Recommendation Report for Planning Permission

REF NO: M/17/19/PL

LOCATION: 14 Baldwin Close
Middleton-On-Sea
PO22 6RQ

PROPOSAL: 1 No. 1-bedroom dwelling & rear extension on existing dwelling (resubmission following M/99/18/PL).

Date: June 2018 Scales: As shown Paper size: A3 Dwg No: AR-129-04/B

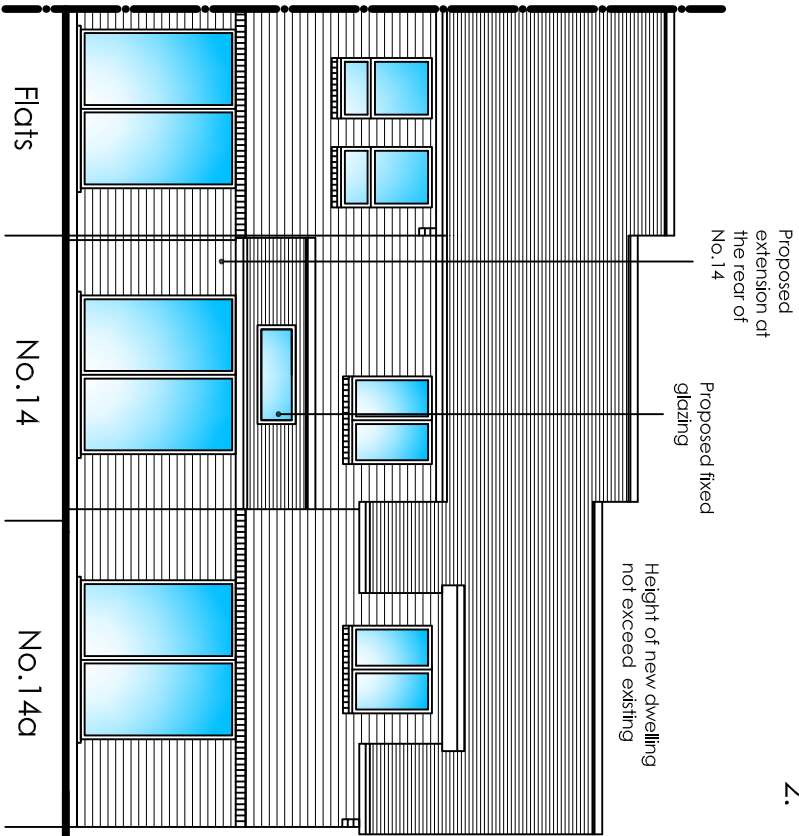
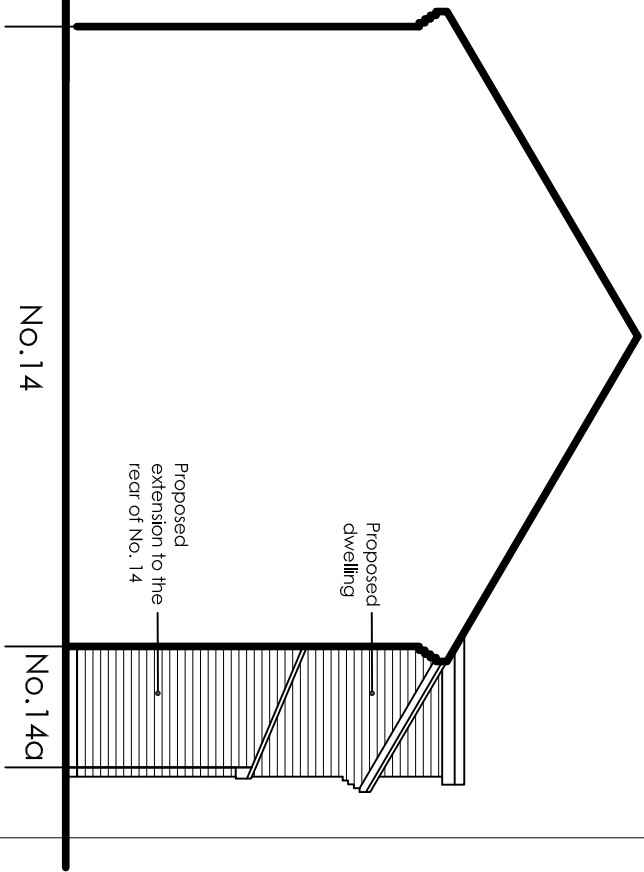
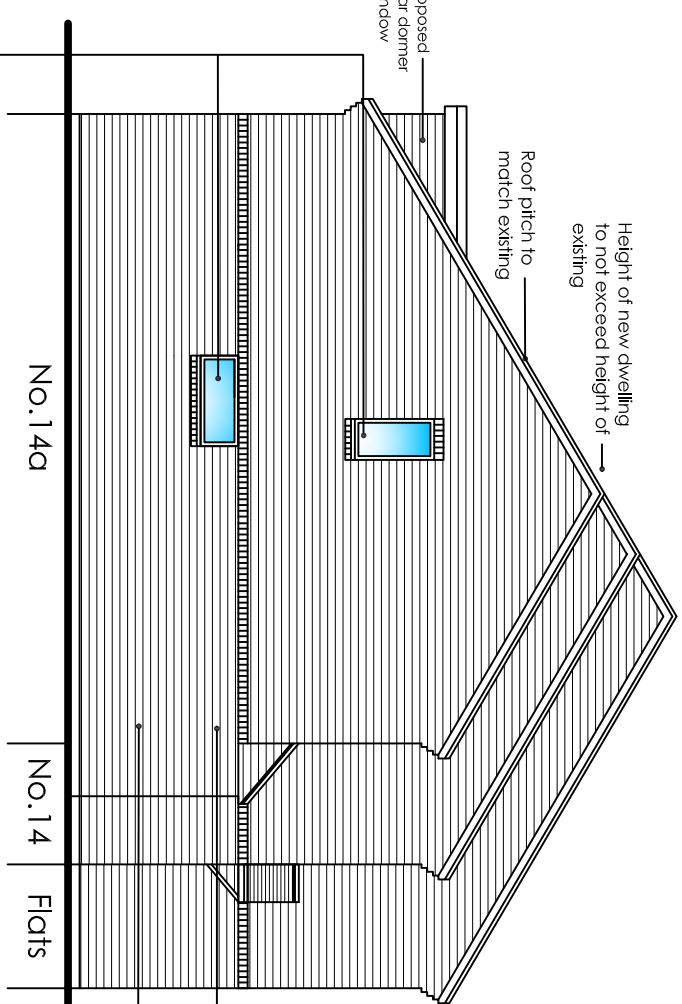
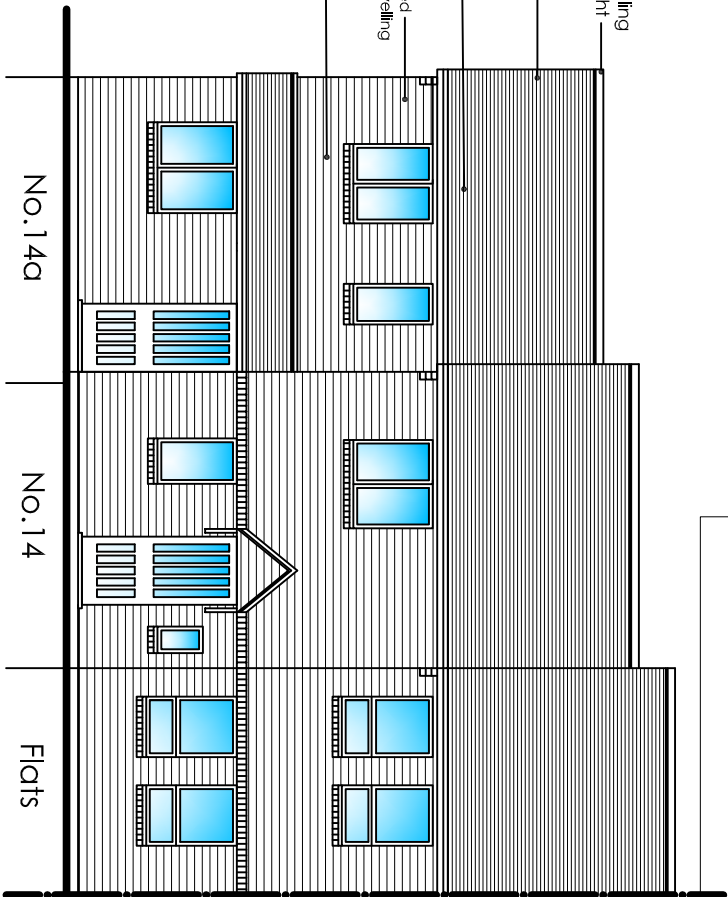
Officers note from plan AR-129-04/B that both the ground floor and first floor side windows (south elevation) are finished with obscure glazing and fixed shut which will ensure that no undue overlooking would occur, however, due to the siting (at approx. 10m distance) the proposal is considered to be overbearing and dominant to the amenity of neighbouring no.11 contrary to policies D SP1 & D DM1 of the Local Plan.

AR-129-03/A

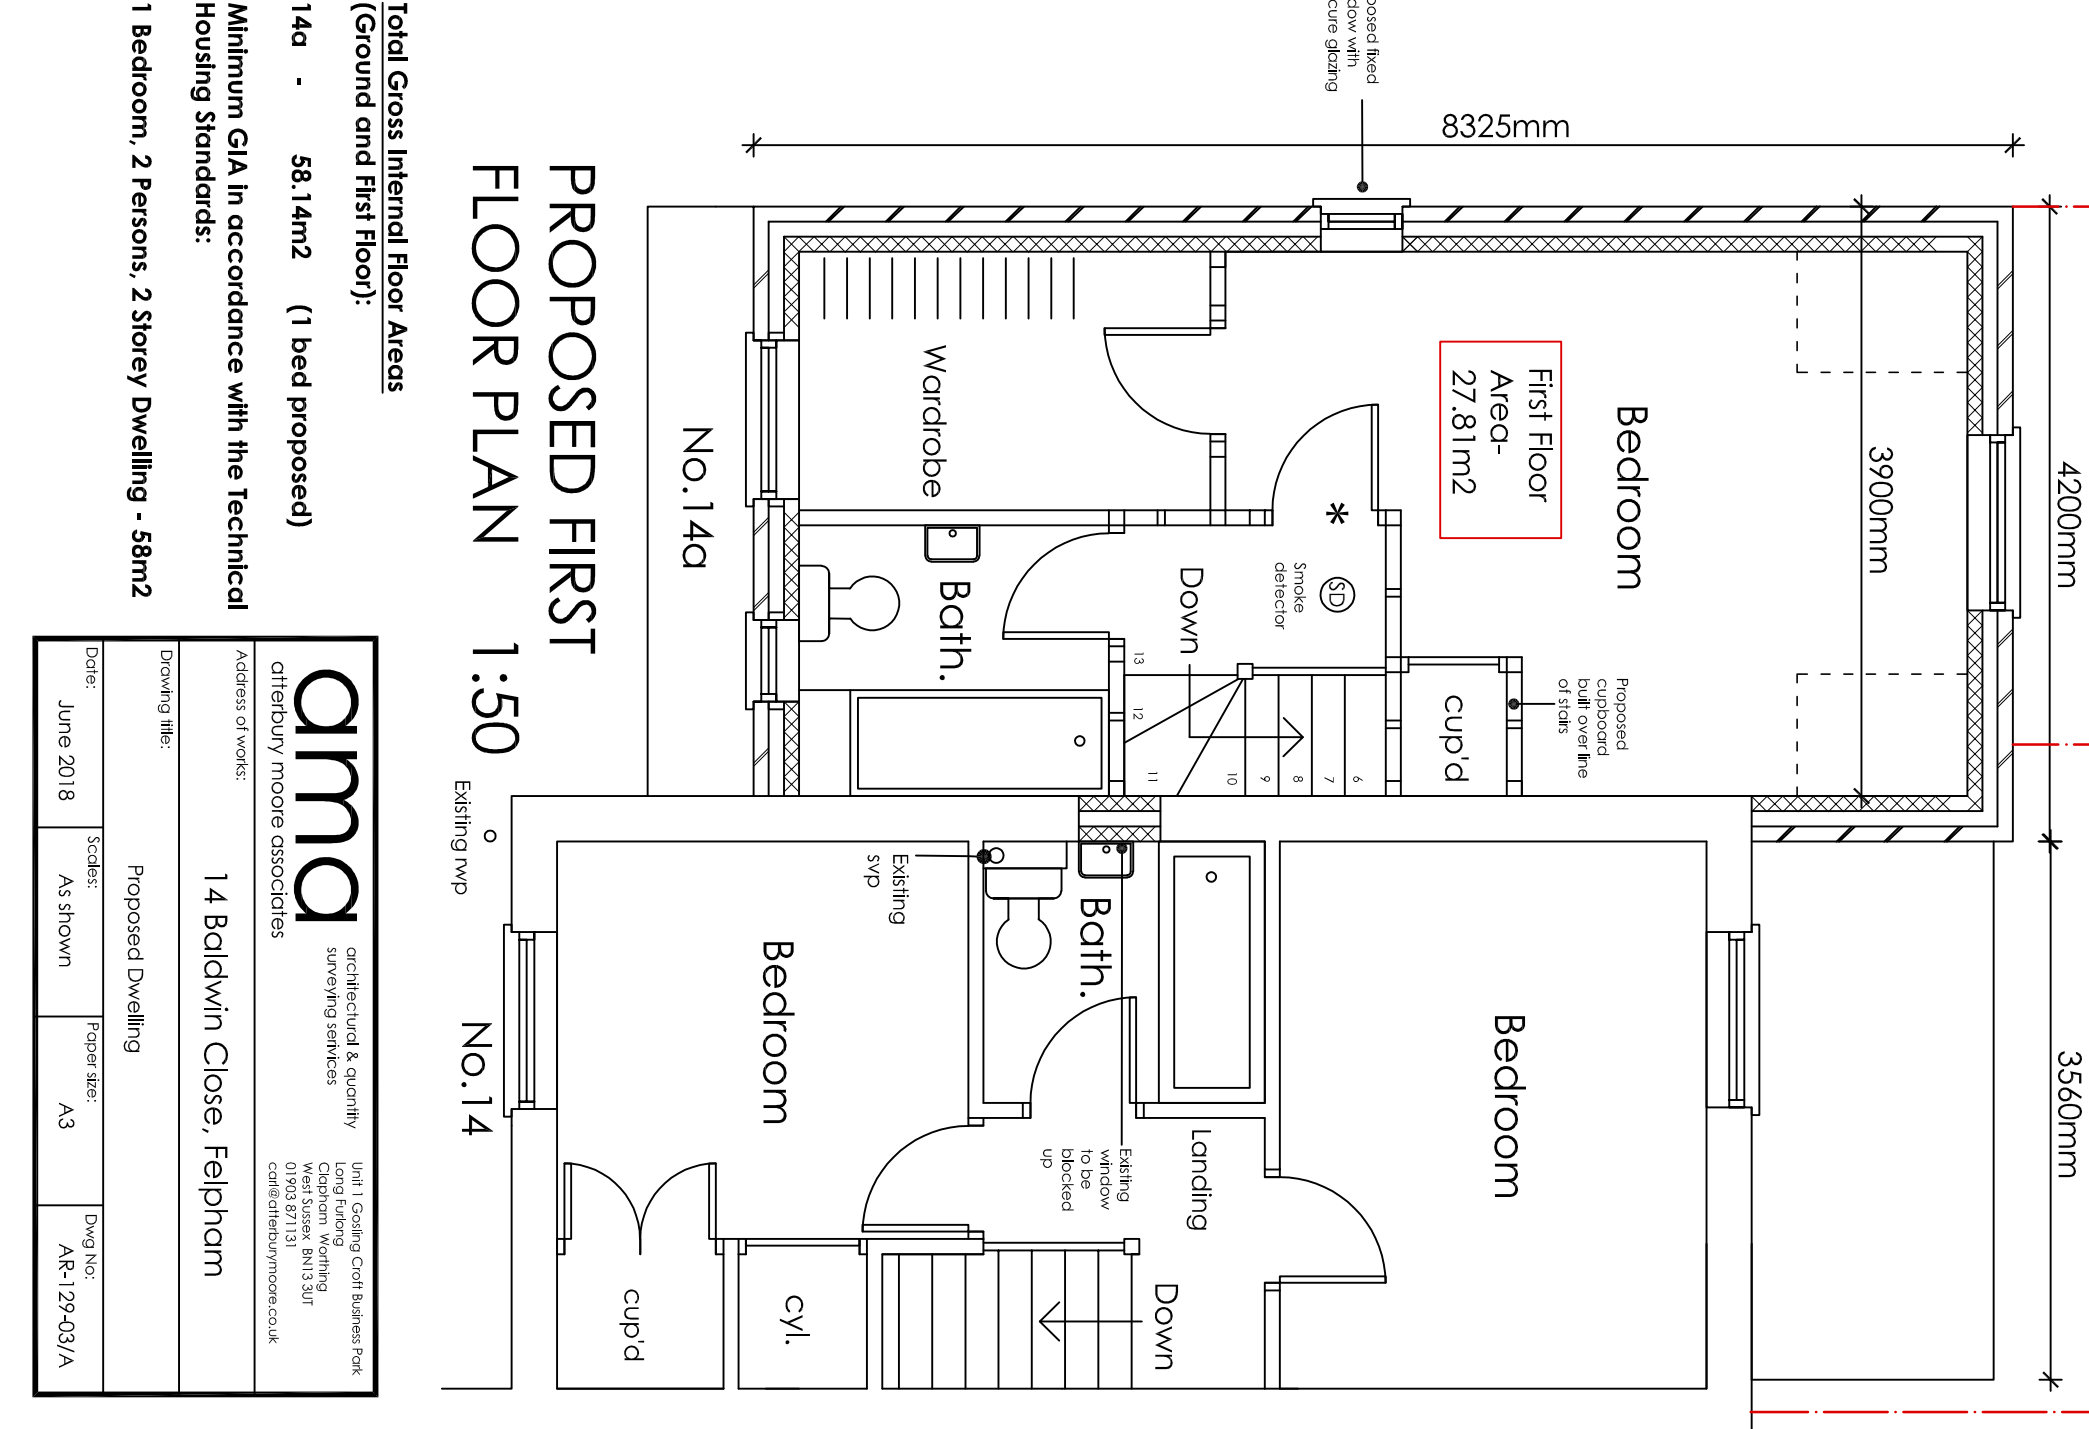
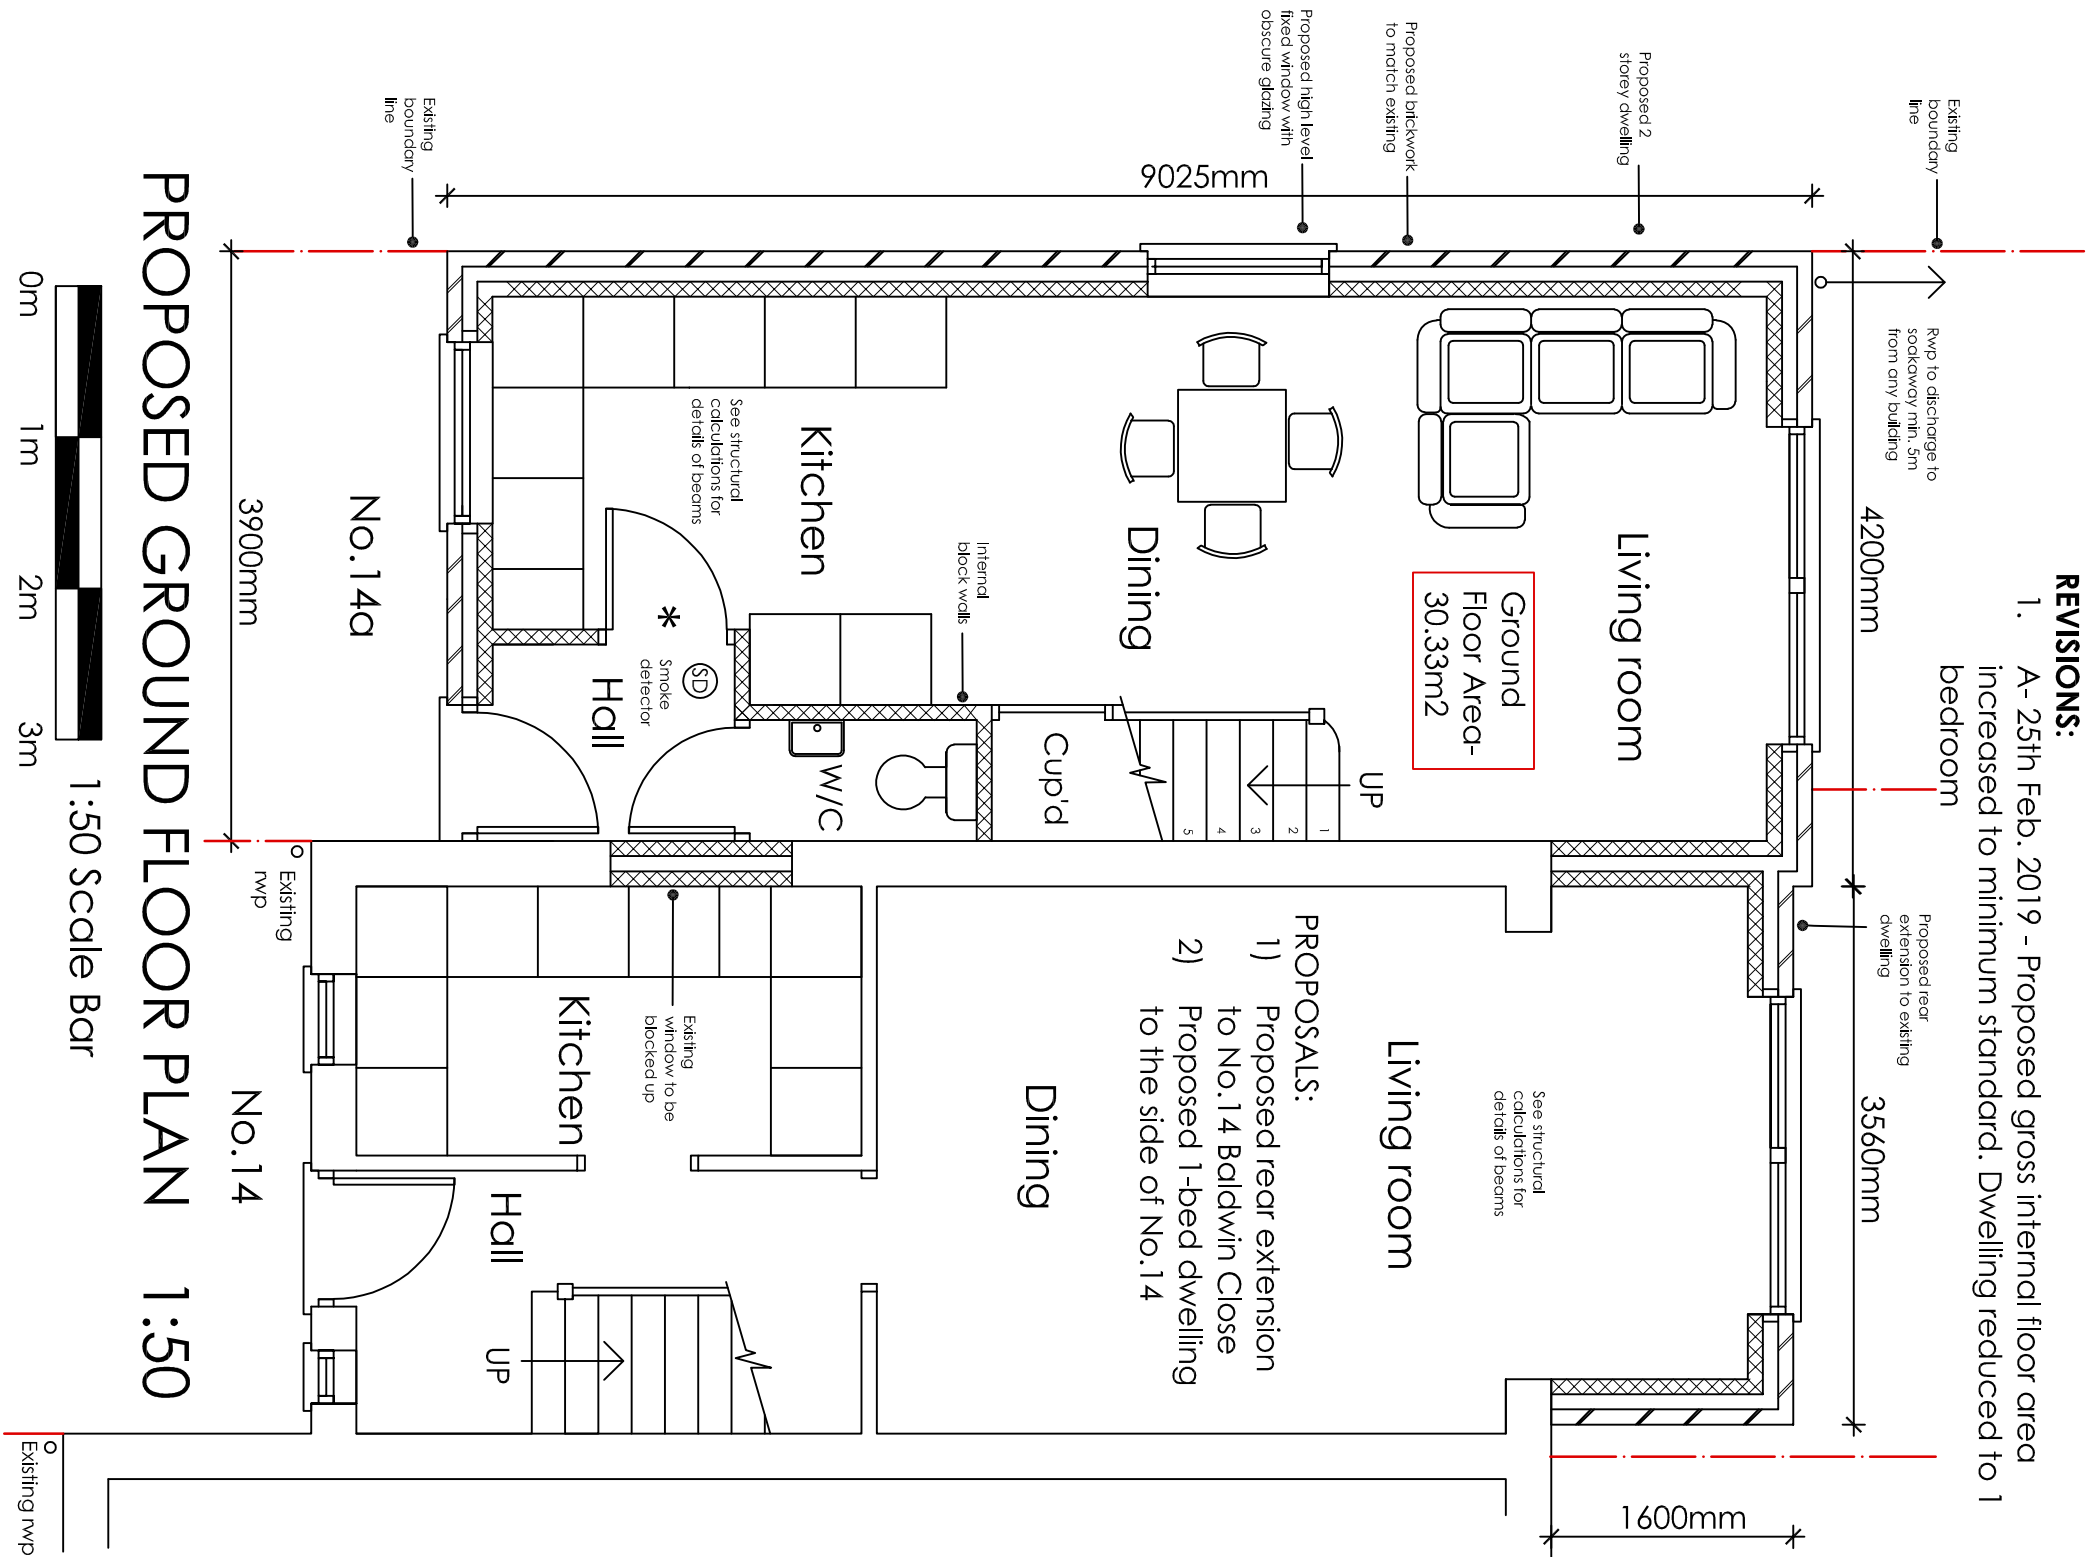
For the type of dwelling proposed the required space standard is 58m² for 1b for 2 persons. The proposed floor area would be 58m² and therefore the dwelling is designed in accordance with the standards which are contrary to Policy D DM2.
